Recommendation Report for Planning Permission for Works or Extension to a Dwelling

REF NO: EP/17/15/HH

LOCATION: 19 Selborne Way
East Preston

PROPOSAL: Front, side & rear extensions (resubmission following EP/112/14/HH).

DWG NO 412/03 REV.A

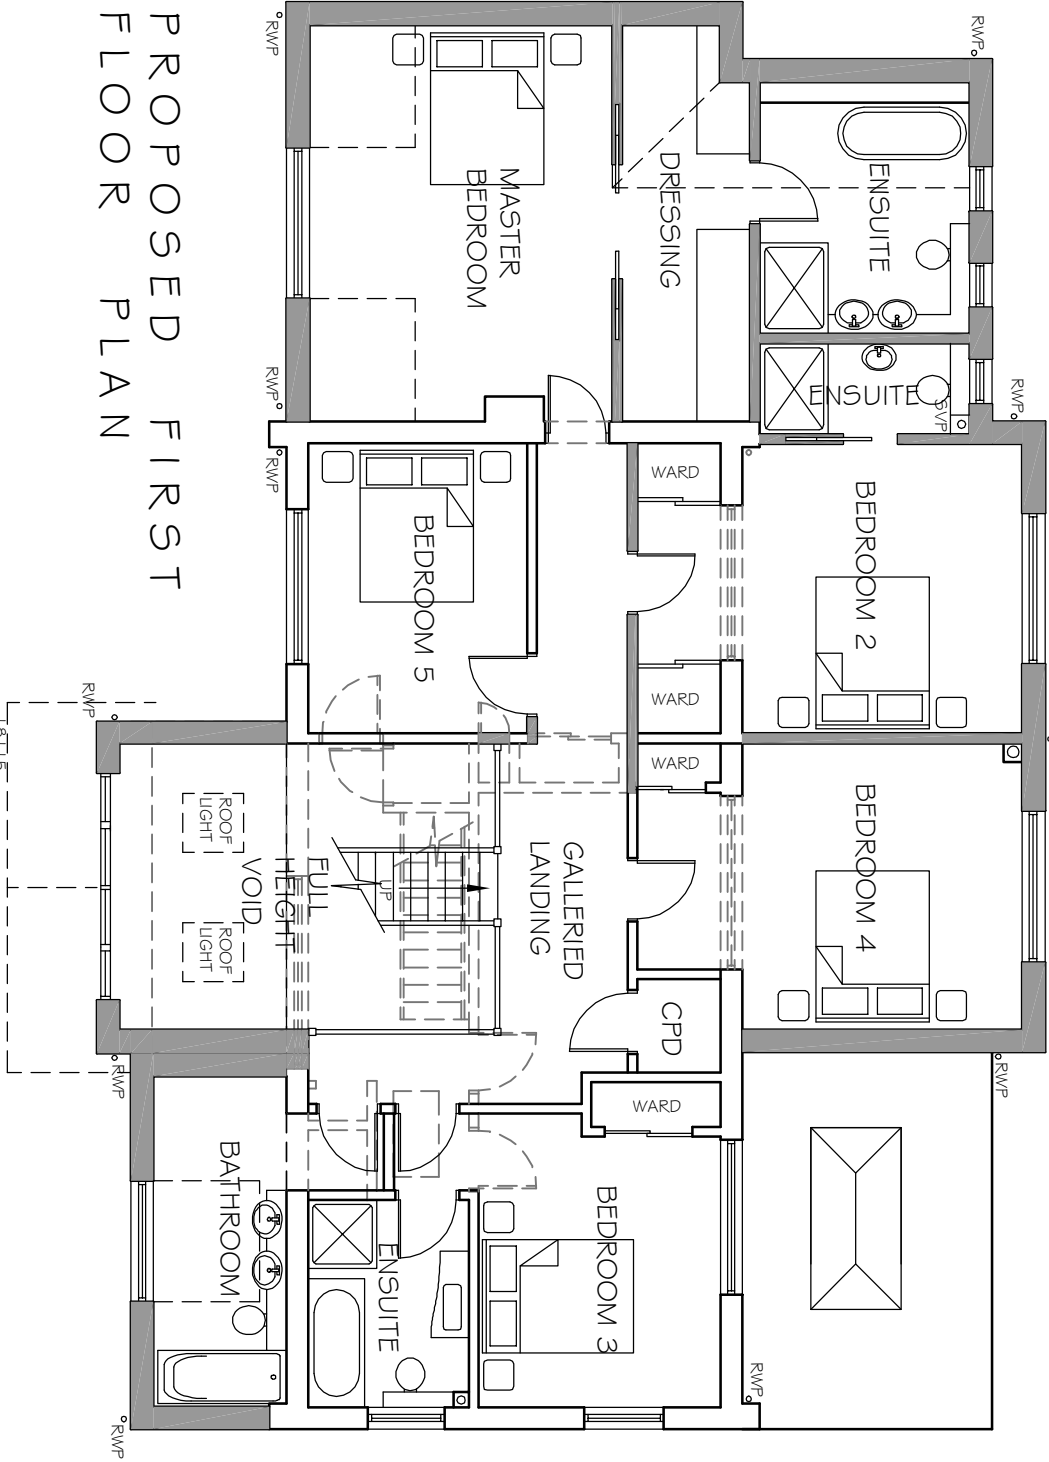
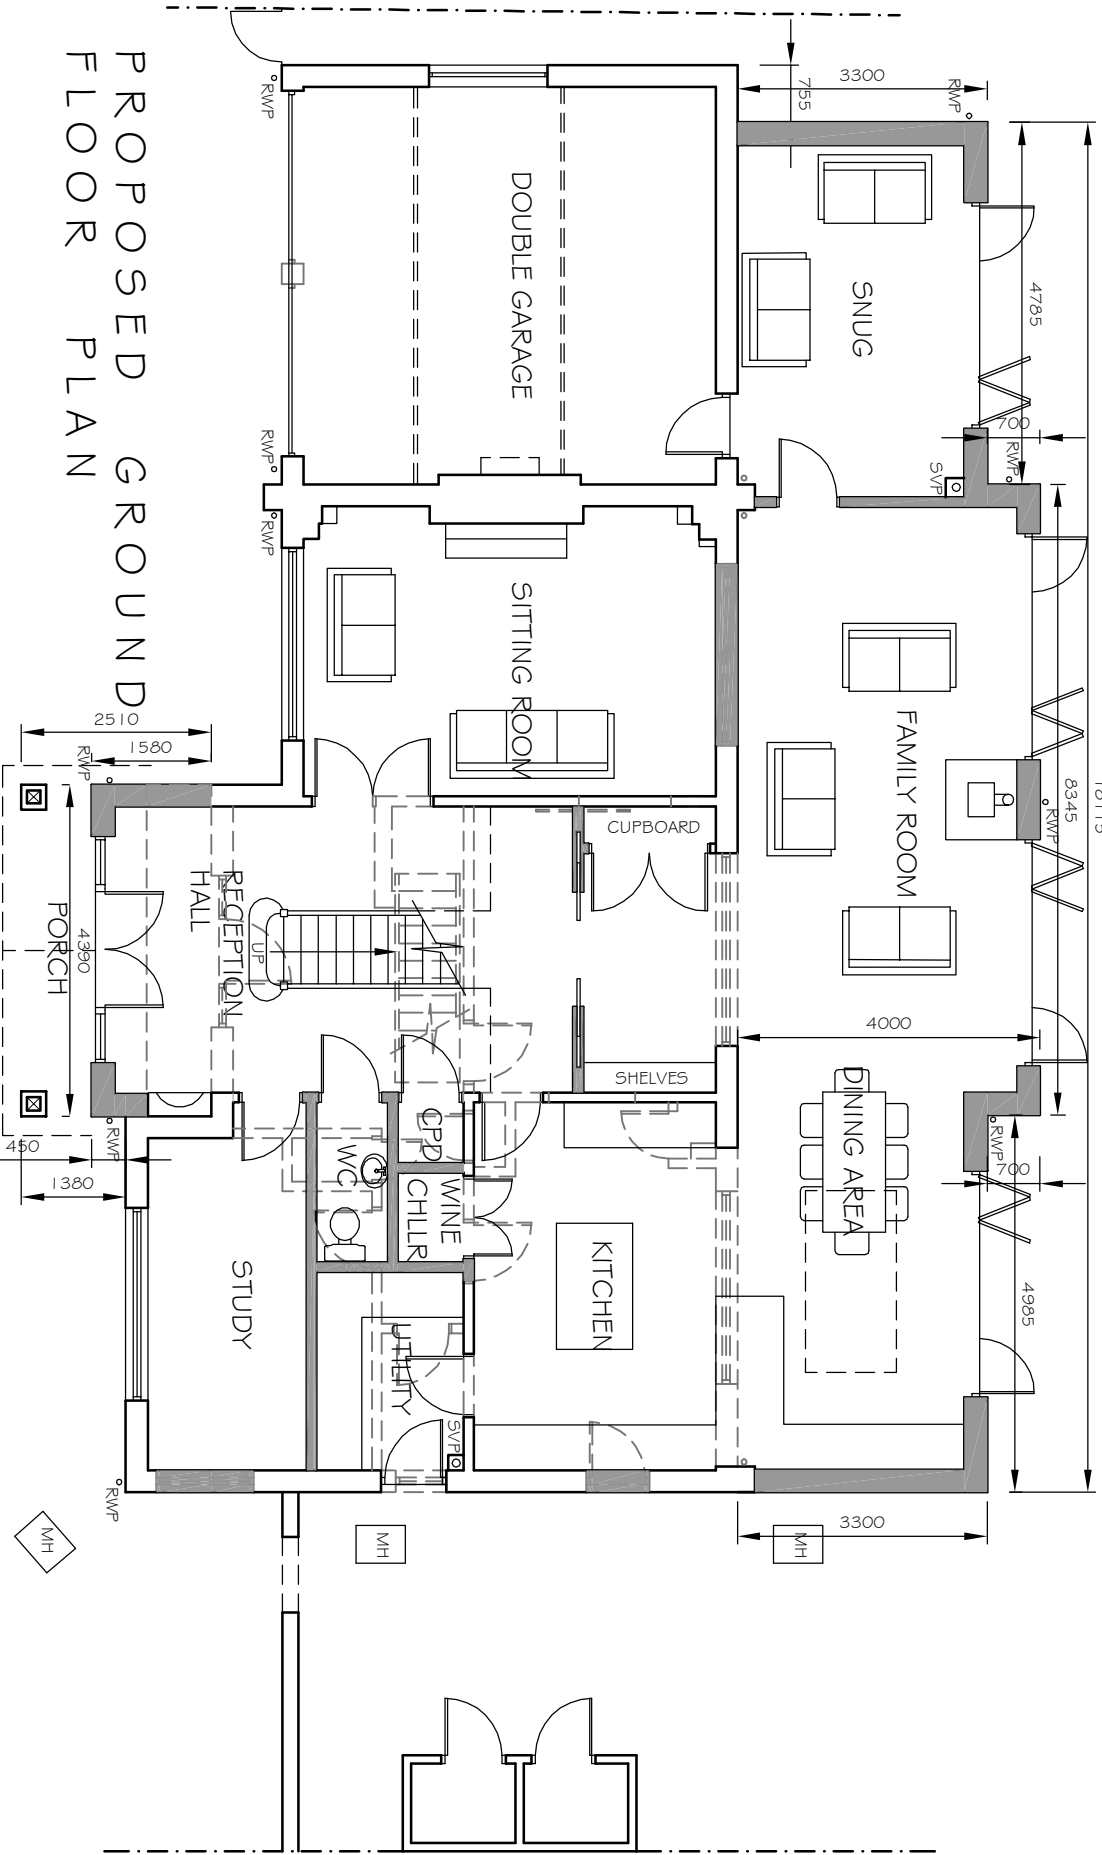
The two storey extension over the garage and to the rear will be situated approximately 1.1m to the northern boundary. However, this is considered acceptable the staggered layout of No. 17 and the dense tall tree screening over 3m in height in this area of the site. To the south and the property of No. 21, there is an acceptable separation distance of over 5m and with hedging in places along the southern boundary which will mean that there are no harmful overbearing or overshadowing effects or any harmful overlooking or loss of privacy.
